Application Number: 2011-401 **Application Date:** 12/7/2011 12:00:00 AM
CBL: 209A-A-16
Project Name: Hilton Garden Inn Expansion
Address: 145 Jetport Boulevard

Project Description: Site Modification to construct a 3-story-36 room expansion of the hotel.
Zoning:
Other Reviews Required:
Review Type: Level I Site Alteration

145 Jetport Boulevard – Hilton Garden Inn

Hilton Garden Inn Expansion – Site Plan Application
Engineering Peer Review Comments, dated December 16, 2011

REDI ROCK GRAVITY WALL CROSS SECTION WITH GUARDRAIL
NOT TO SCALE

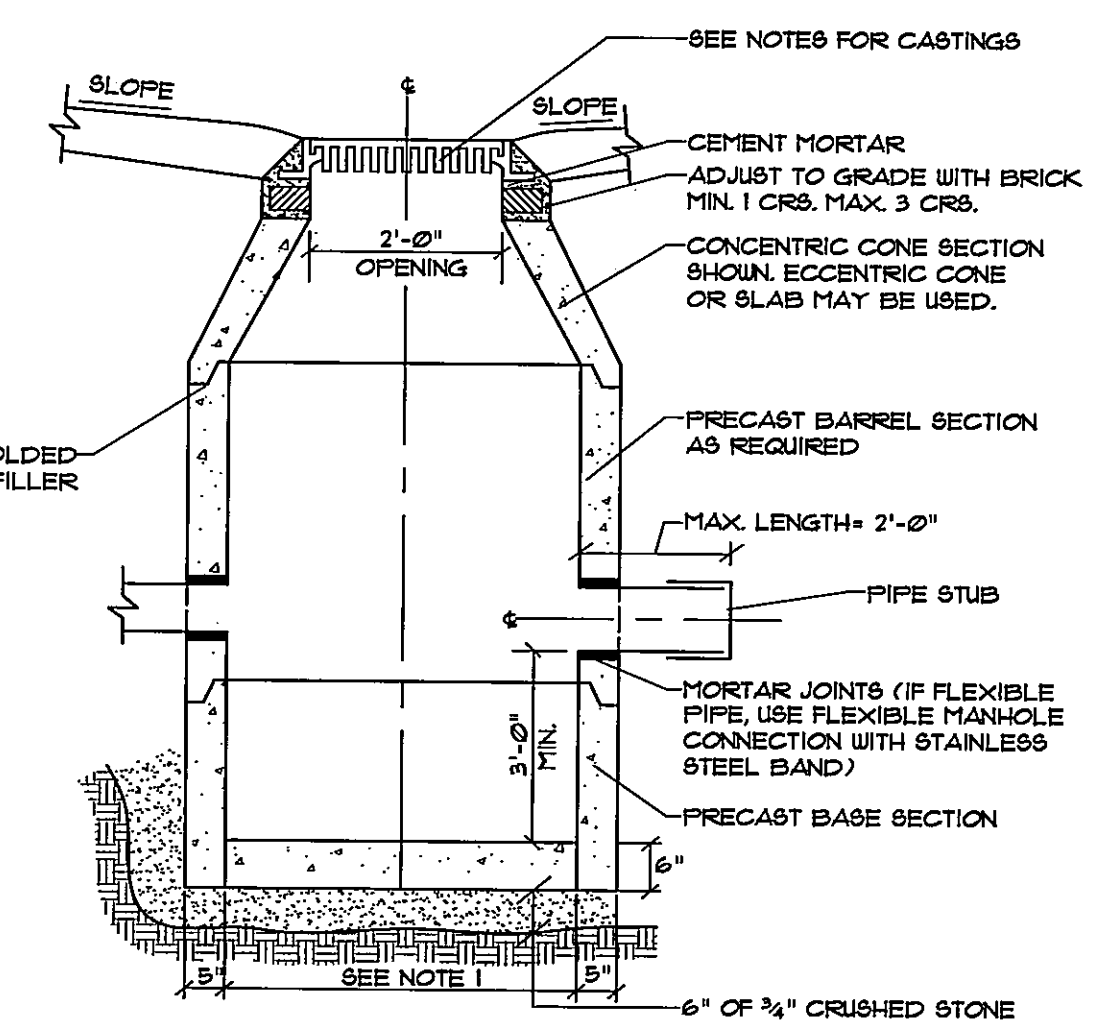
- *The Applicant should verify that groundwater and bedrock are at least one foot below the bottom of the filter. If these depth requirements cannot be met, the applicant should account for an impermeable liner system in their design.*

The seasonal high groundwater table is based on boring and test pit logs obtained during the initial project's construction. The location of the two closest explorations indicates

that groundwater varies from approximately 3.5 to 5.0 feet below ground surface in this area of the site. The requested liner has been added to the plans. Notes have been added to the plan indicating that the Engineer is to confirm the groundwater elevation and liner requirements prior to construction.
